CITY OF ALBUQUERQUE

**Re: 4 Unit Townhouse Development
1203 Griegos Road NW
Grading and Drainage Plan
Engineer's Date 12-22-14 (F14D070)**

Based upon the information provided in your submittal received 12-31-14, the above referenced plan is not approved for Grading Permit nor Building Permit. Please address the following comments:

4 UNIT TOWNHOUSE DEVELOPMENT GRADING AND DRAINAGE PLAN

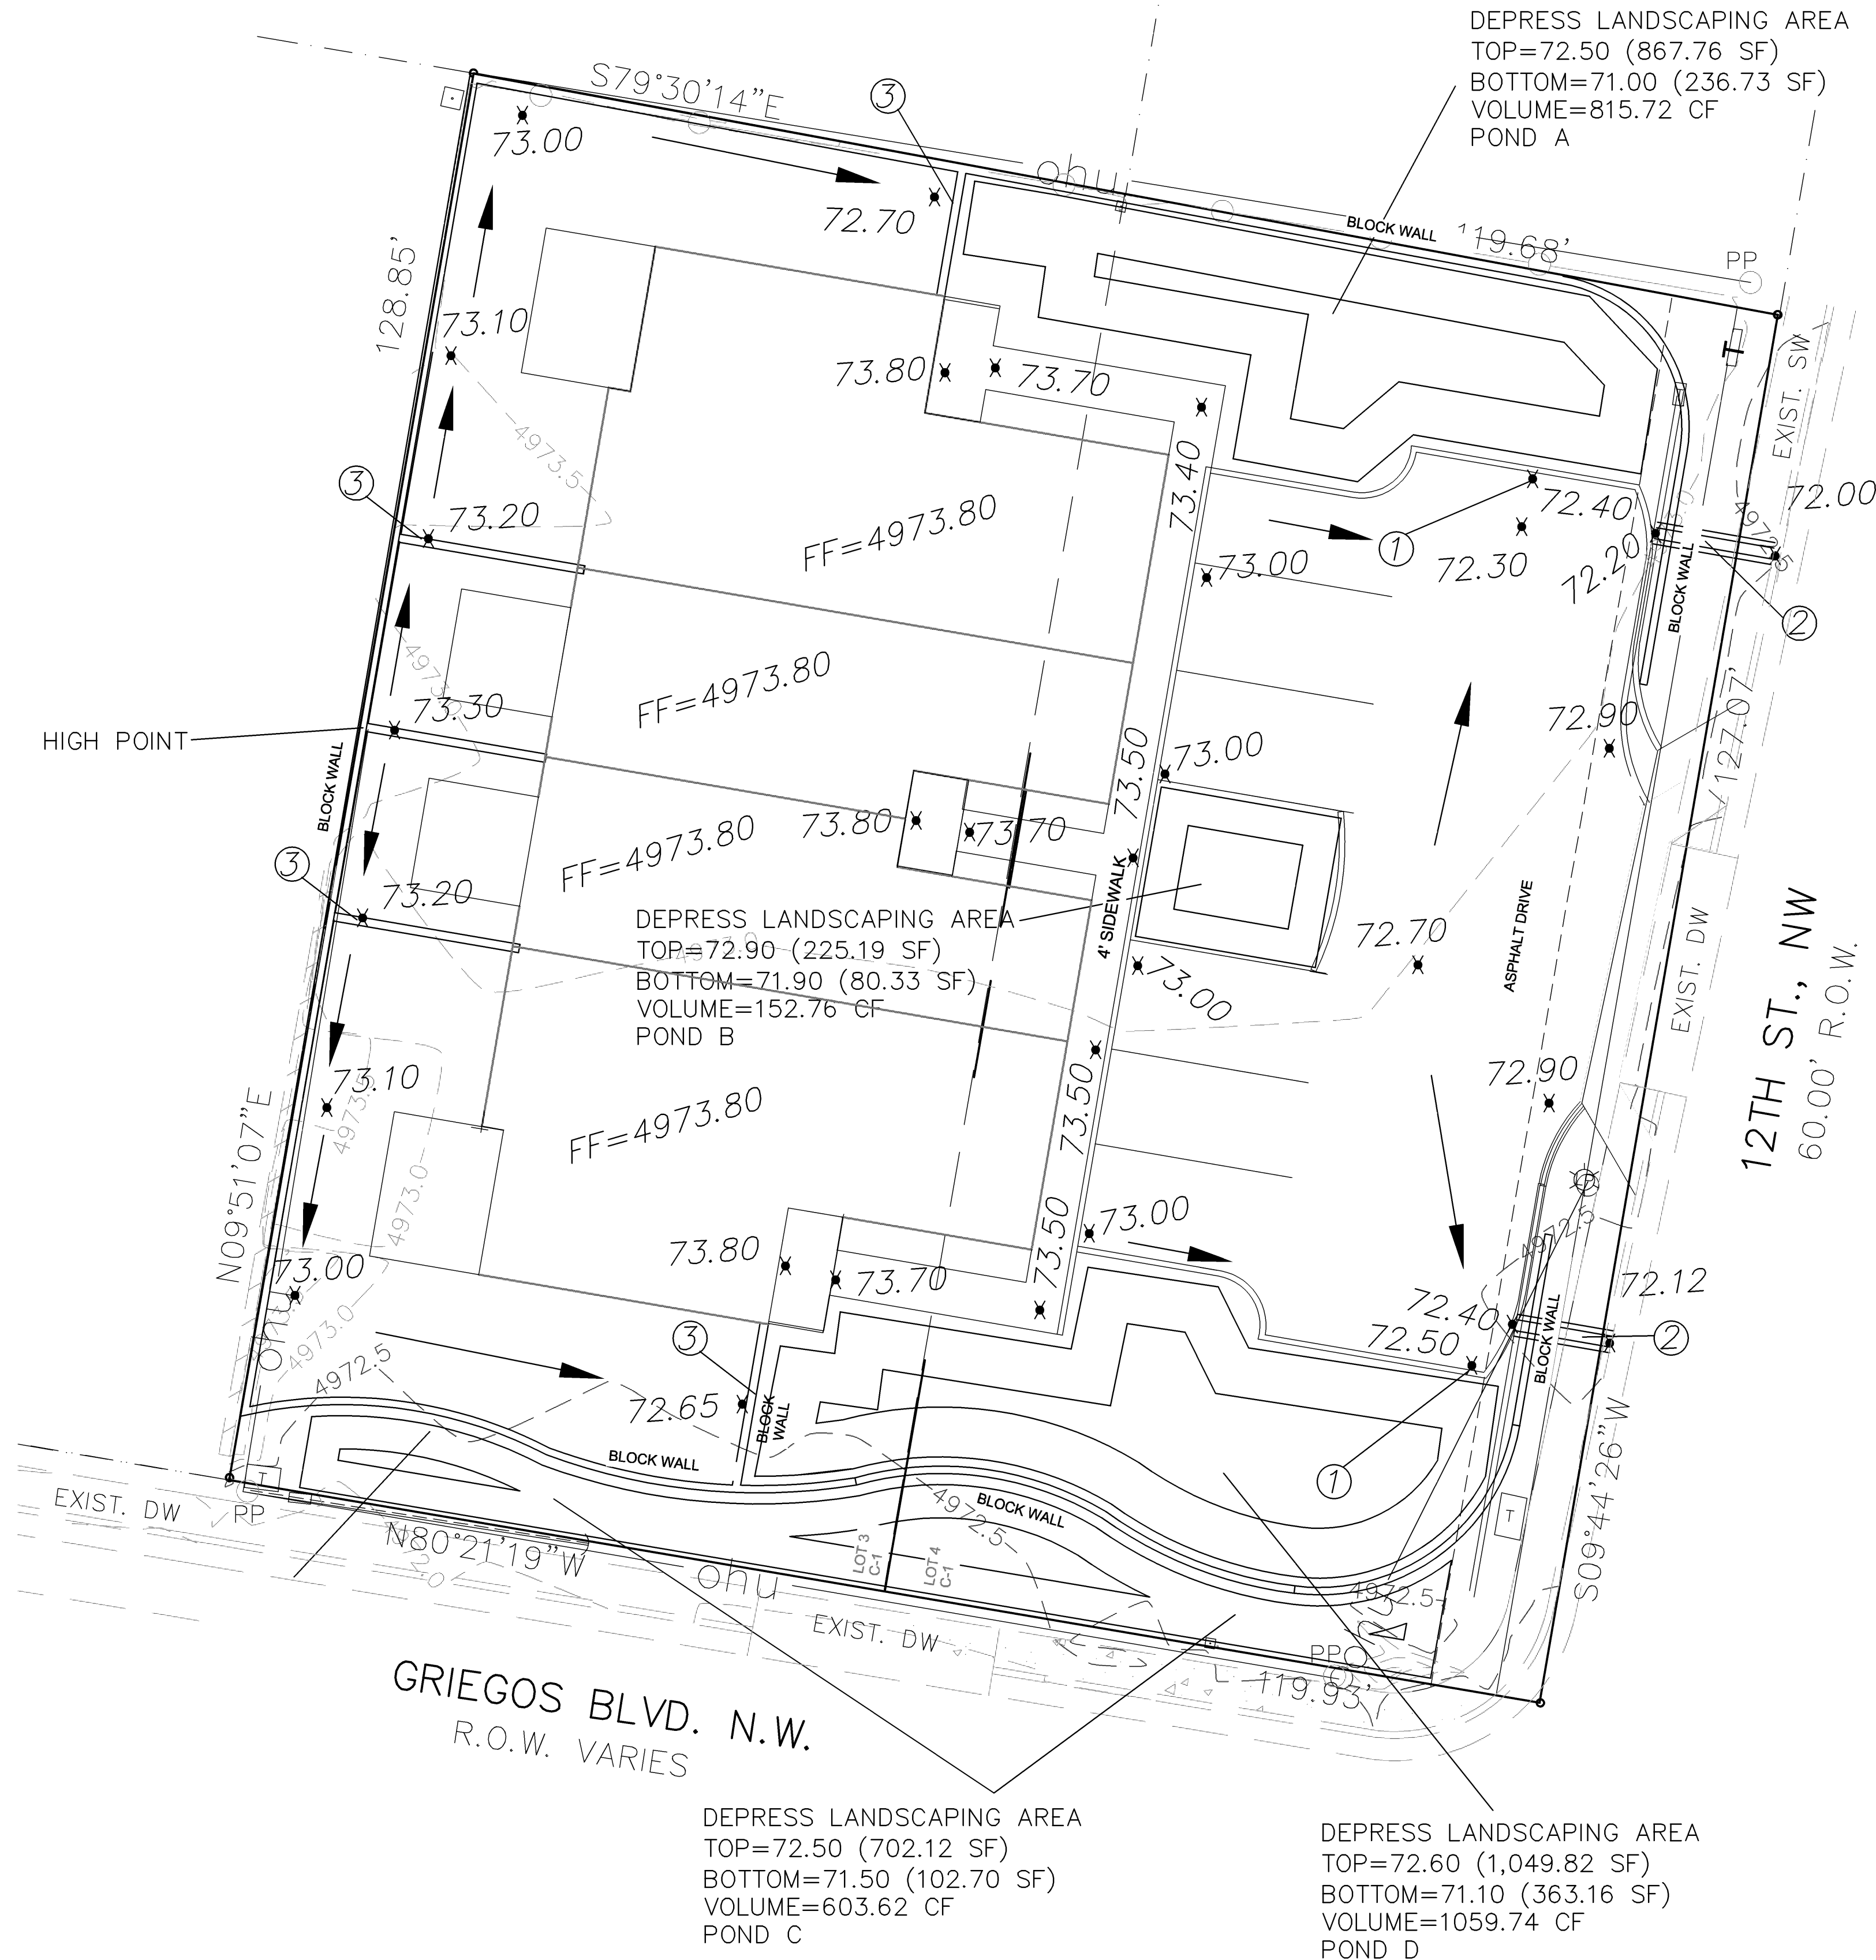
1. In the Valley (the area between the Rio Grande and Broadway), the volume required for a retention pond is 0.5 inch multiplied by the area of the site. Include a Water Surface Elevation for each pond. This will reduce the size of the ponds significantly. (Also note, for detention in the Valley, the allowable discharge is a maximum of 2.75 cfs/acre.)

2. Although retention has been provided, the First Flush still needs to be discussed. Per the City Drainage ordinance, the 90th Percentile Storm Event, which is 44 inches, is to be managed. Reduce 0.44 inch by the 0.1 inch for the initial impervious abstraction in Table A-6 of Section 22 of the DPM. Multiply the remaining 0.34 inch by your impervious area. This is the amount of the First Flush necessary for the site. Show that amount on your plans. State that the capacity provided by the retention pond is greater than what is required for the First Flush.

3. The Grading and Drainage plan should match the site plan. The site plan submitted to DRB has two islands in the parking lot, but the Grading and Drainage plan only has one.

4. Two sidewalk culverts are called out that are in the public ROW. Provide S0-19 language and signature block on the plan which is attached. Request SO-19 review on the DTIS.
